**KIRKLEES METROPOLITAN COUNCIL  
INVESTMENT & REGENERATION SERVICE**

**DELEGATED DECISION TO DETERMINE PLANNING APPLICATIONS**

Reference No:	<b>2023/62/91436/E</b>
Site Address:	10, Mavis Avenue, Scout Hill, Dewsbury, WF13 3RU
Description:	Erection of extensions, front dormer and associated alterations
Recommending Officer:	Katie Wilson

## HOUSEHOLDER DELEGATED REPORT

Front Elevation

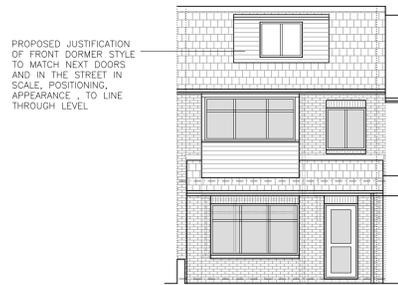
<b>Dormer windows should:</b>	<b><u>Yes - COMPLY</u></b>	<b><u>No - JUSTIFY</u></b>
relate to the appearance of the house and existing roof	Yes – in officers' opinion it would relate reasonably well to the appearance of the existing terraced house.	
be designed in style and materials similar to the appearance of the existing house and roof	Yes – The house has some white render on the front elevation and the use of white upvc cladding would reflect this material. It would also be in keeping with other front dormers to houses in the same street-scene.	
not dominate the roof or project above the ridge of the house	Yes – it would not dominate the roof or project above the ridge level of the existing house.	
	Yes

be set below the ridgeline of the existing roof and within the roof plane;		
be aligned with existing dormer windows on neighbouring properties in the same roof plane where relevant.	Yes

Facing materials and detailing	<ul style="list-style-type: none"> <li>• KDP 9 of the SPD</li> <li>• Policy LP24 Design (d) (iii) of the KLP</li> <li>• Chapter 12 of the NPPF</li> </ul>	The wall and roofing materials of the extensions would be to match the existing house, and dormer window would be clad in white upvc boards to match those on the front of the house.	
Roof style	<ul style="list-style-type: none"> <li>• KDP 1 and 2 of the SPD</li> <li>• Policy LP24 Design (a), (c) and (d) of the KLP</li> <li>• Chapter 12 of the NPPF</li> </ul>	The roof style of the rear and front extensions would be to match the existing. The dormer would have a flat roof, which reflects to some degree the box bay windows on the front elevation and other dormer windows in the same row.	
Window proportions	<ul style="list-style-type: none"> <li>• KDP 1 and 2 of the SPD</li> <li>• Policy LP24 Design (a), (c) and (d) of the KLP</li> <li>• Chapter 12 of the NPPF</li> </ul>	There are a mixture of window styles within the row and those proposed would be suitable for a domestic extension are considered acceptable.

4. The external front and side cheeks of the front dormer hereby approved shall be clad in white upvc, and thereafter retained.

Rear Elevation

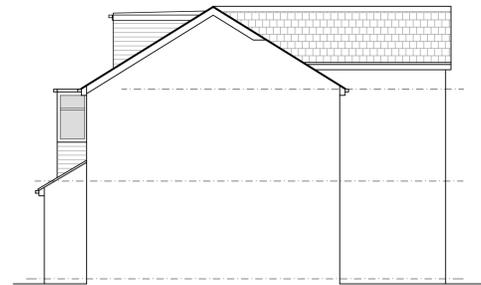
<b>Two storey rear extensions should:</b>	<b><u>Yes - COMPLY</u></b>	<b><u>No - JUSTIFY</u></b>
<b>be proportionate to the size of the original house and garden;</b>	Yes. The footprint of the proposed rear extension would be less than that of the host property.	
<b>Not normally cover more than half the total area around the original house (including previous extensions and outbuildings)</b>		The proposal would cover much of the back yard, but retain much of the front garden. For the reasons given above this is considered to justify not complying with this part of the SPD.
<b>Not exceed a height at eaves of 3 metres</b>		No, the eaves would be in excess of 3.0m high

where the extension is within 1.5 metres of the property boundary		and within 1.5m of the property boundary. However as described before most of the other terraced houses in the same row have very similar extensions.
Not project out more than 3 metres from the rear wall of the original house for a semi-detached or terraced house, or by 4 metres for detached properties	Yes, it would meet this criteria.	
Retain a gap of at least 1.5 metre from a property boundary, such as a wall, fence or hedge.		No – For the reasons given before, the proposal is considered acceptable.
Not adversely affect habitable room windows where they adjoin a neighbour's boundary	Yes, the neighbouring properties already have similar extensions up to the mutual boundary. The proposed extension would fill in the gap and project no further. As such there would be no significant overlooking impacts.

Ground floor plan

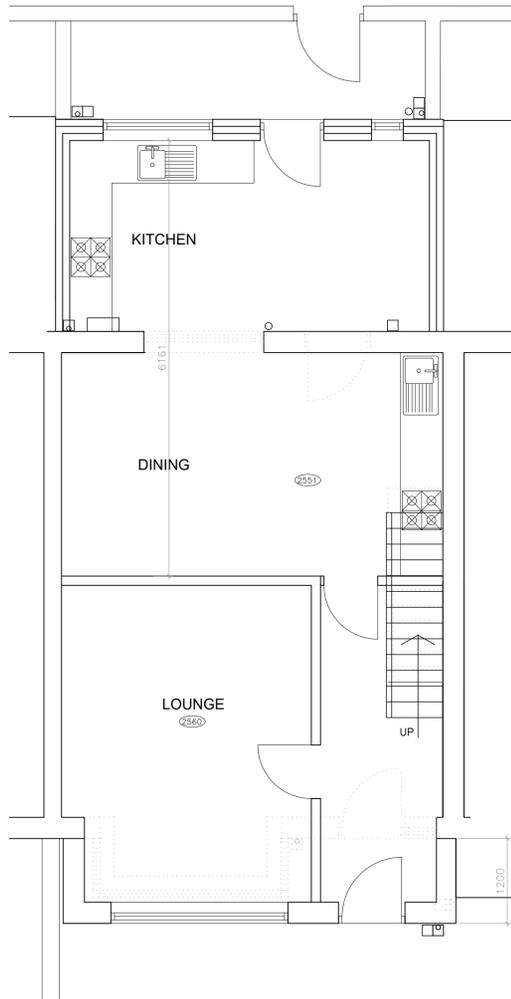
<b>Single storey front extensions should:</b>	<b><u>Yes - COMPLY</u></b>	<b><u>No - JUSTIFY</u></b>
The house is set well back from the pavement or is well screened; and	Yes – the extension would be set back from the pavement. Approximately 3.6m

The extension is small, subservient to the original building, well-designed and would not harm the character of the original house or the area; and	Yes – the extension would project just 1.2m and appear subservient. It has also been designed with a lean-to roof, in-keeping with host property.	
The materials and design match the existing features of the original house; and	Yes – materials would match existing	
The extension would not unreasonably affect the neighbouring properties.	Yes – the modest scale would result in minimal impact on neighbouring property.
